FINAL DRAINAGE REPORT

**LOT 2 ELM GROVE VILLA SUBDIVISION
SMITH PLUMBING & HEATING
PCD Filing No.: PPR2143**

DATE:
November 2021

WQ PLAN

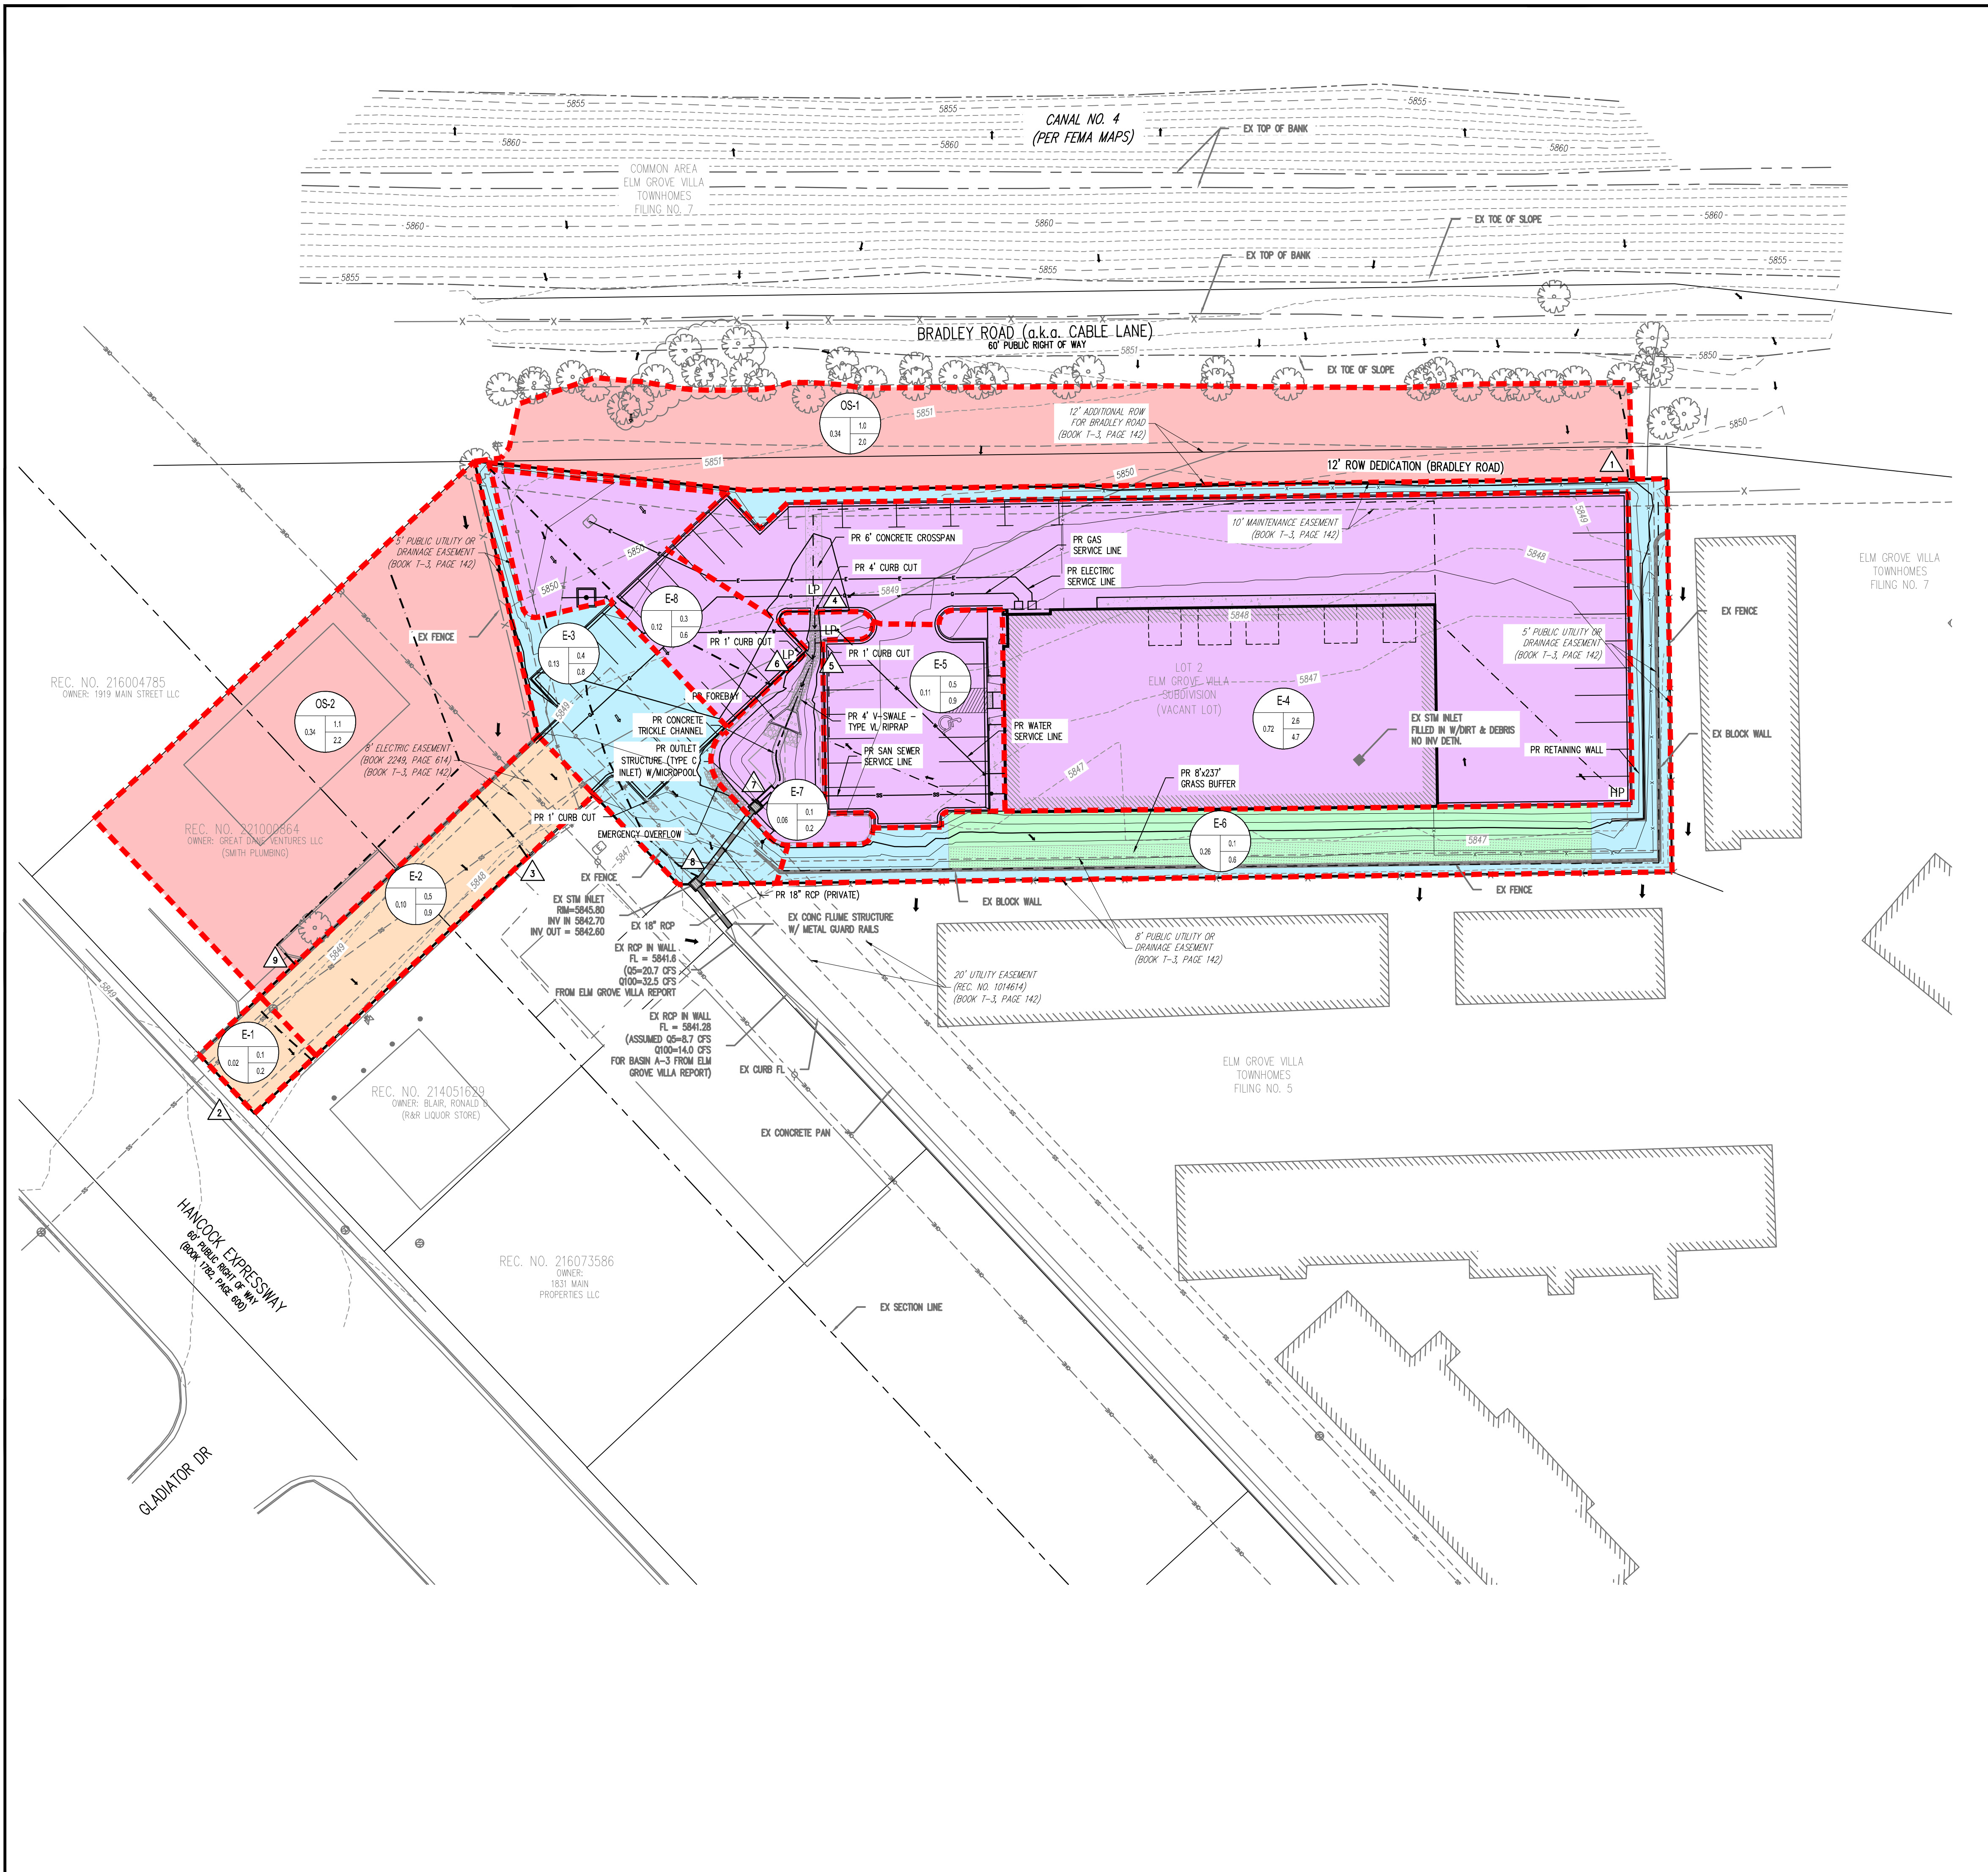
Discuss whether or not this is a suitable outfall, per ECM, Chap 3.2.4. Does the pan have sufficient capacity for the increased flows? Also, the pan just ends in the middle of the road (per screenshot provided below from Google Street) and isn't directed towards the detention pond. Discuss.

How is flow conveyed from concrete pan to existing detention pond?

No discussion about the overflow is seen above.
